Planning Act 2008, Scottish Power Renewables, Proposed East Anglia One North (EA1N)
and Two (EA2) Offshore Windfarms

Historic England Deadline 9 Response

Confirmation of Historic England Comments at Deadline 9 - 15th April 2021

Drawing file: EN010078 / EN010078-004513-ExA.AS-31.D8.V1 04 EA1N&EA2 Photomontages with Potential National Grid Extensions Bays CHVP3 Appendix 24.7 Fig 8.pdf

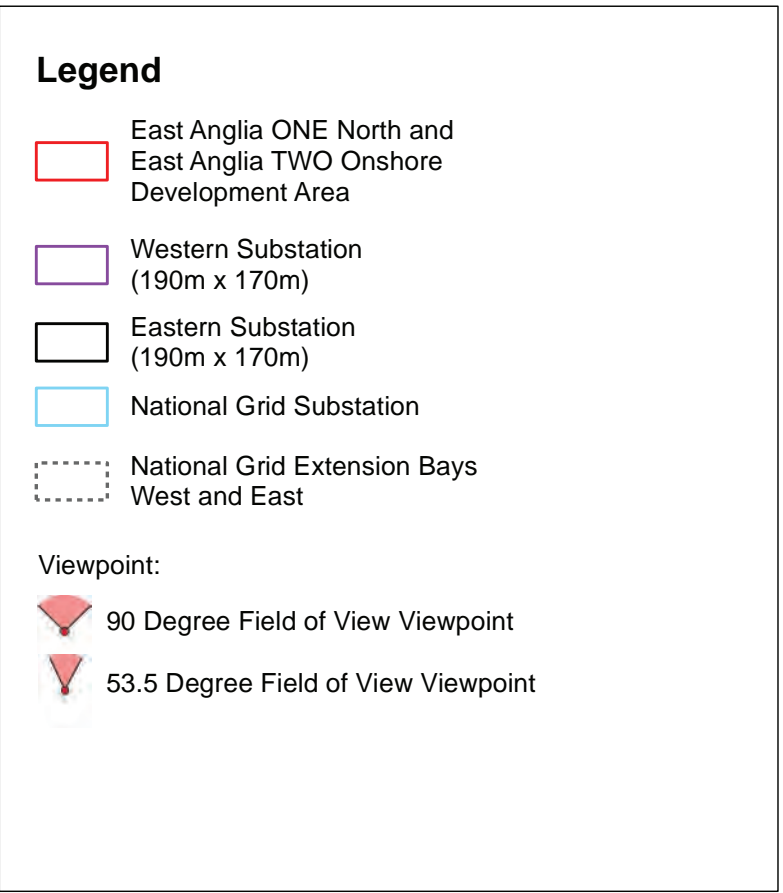
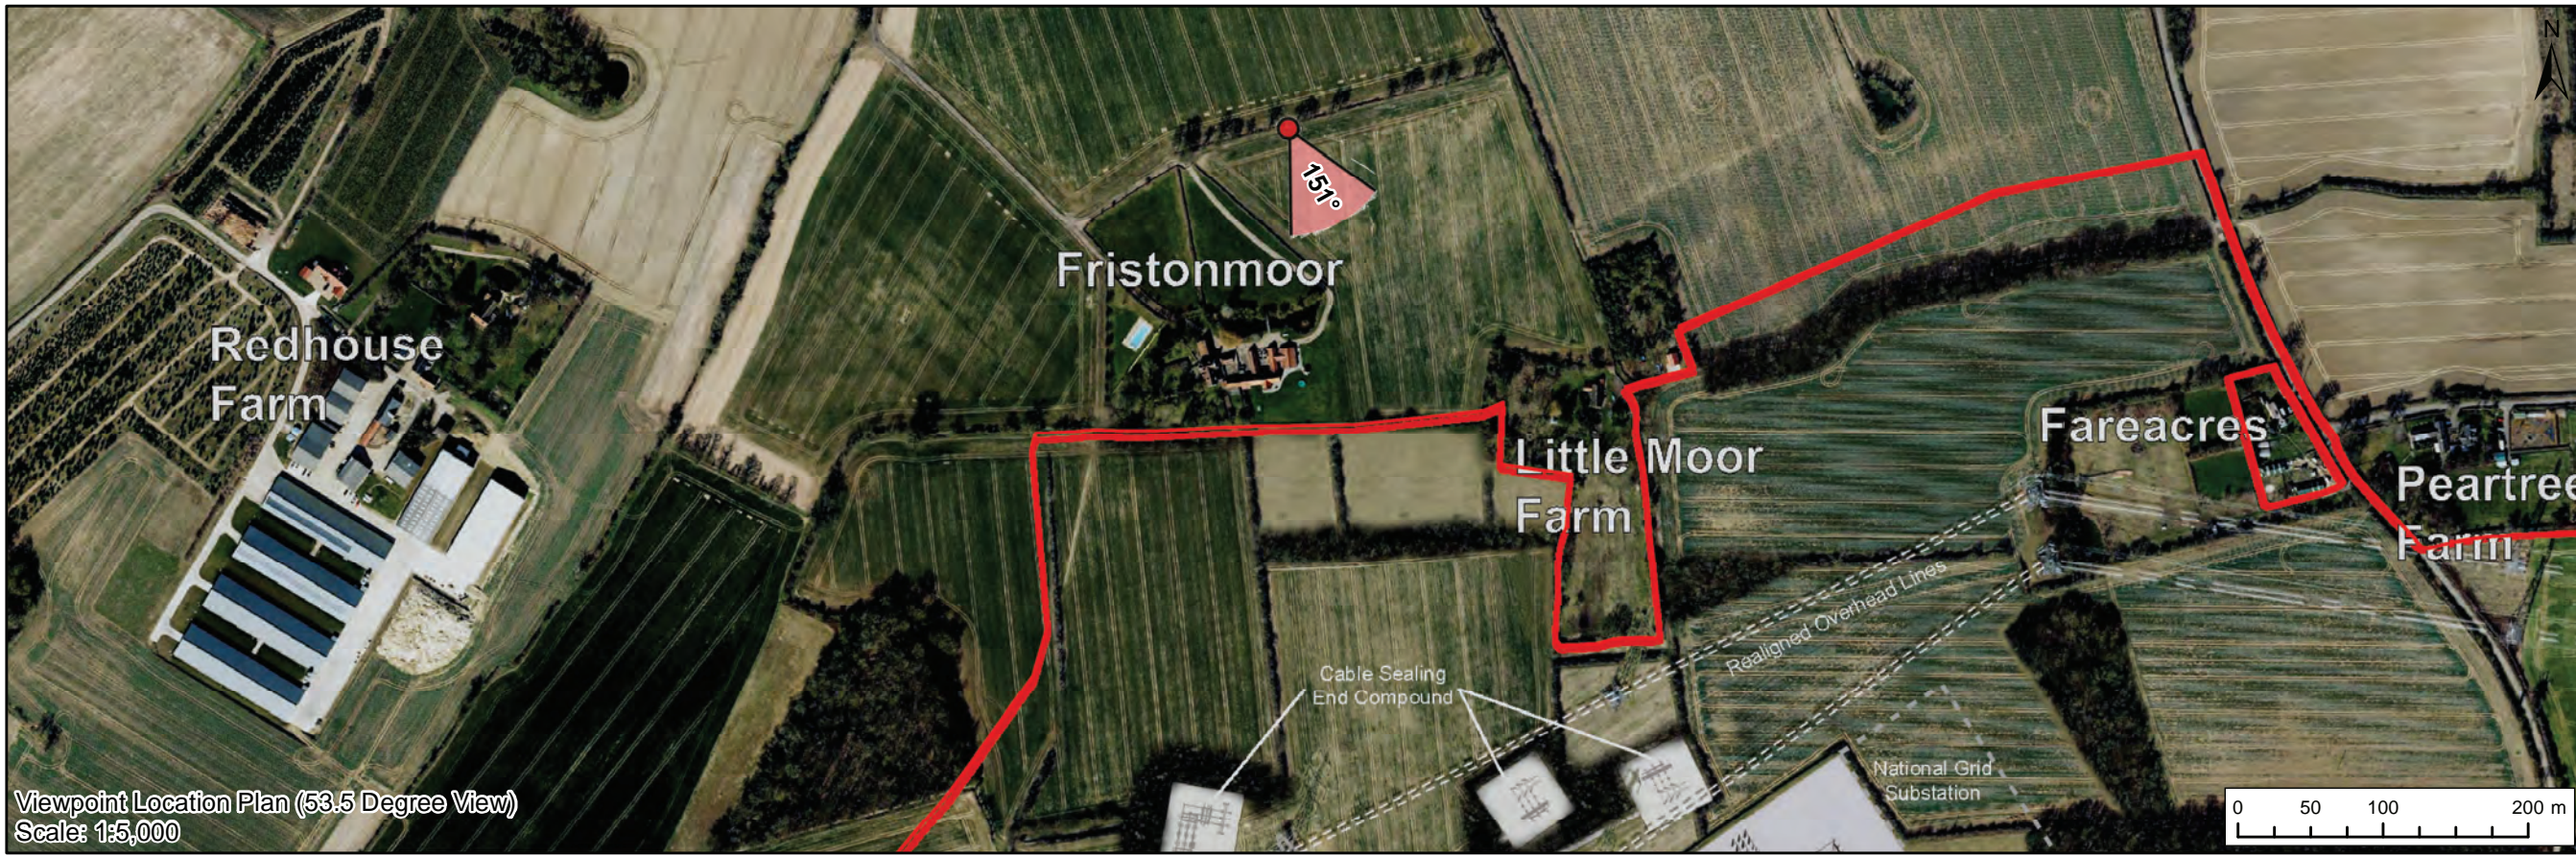
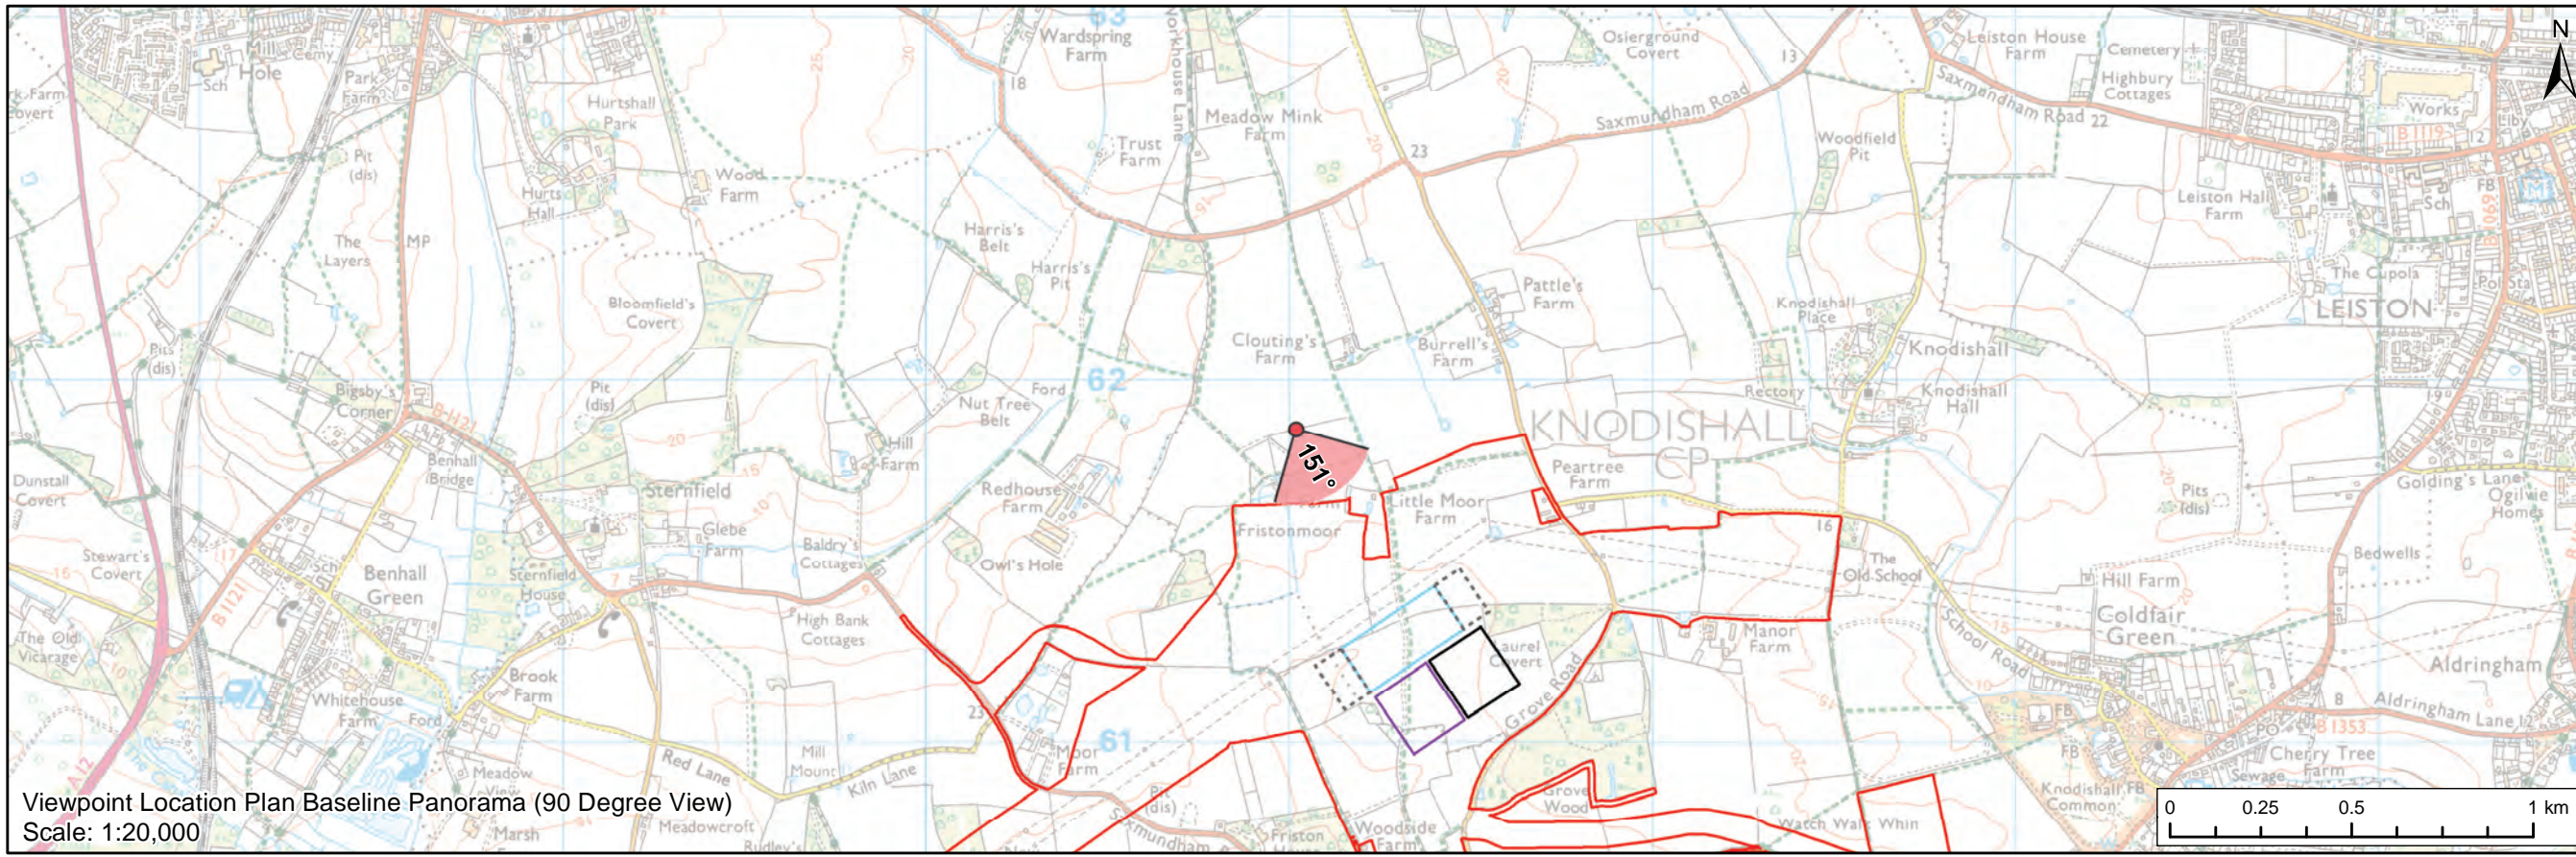
This is demonstrated in part by the Cultural Heritage Viewpoints (e.g. CHVP3 -Appendix 24.7, Figure 8 - Update) which indicates that the extensions to the substation when combined with all the proposed development are likely to further decrease the visibility of the church in the

landscape and increase the amount of development in some views, particularly from the north towards Friston and from the north west around Friston Moor.
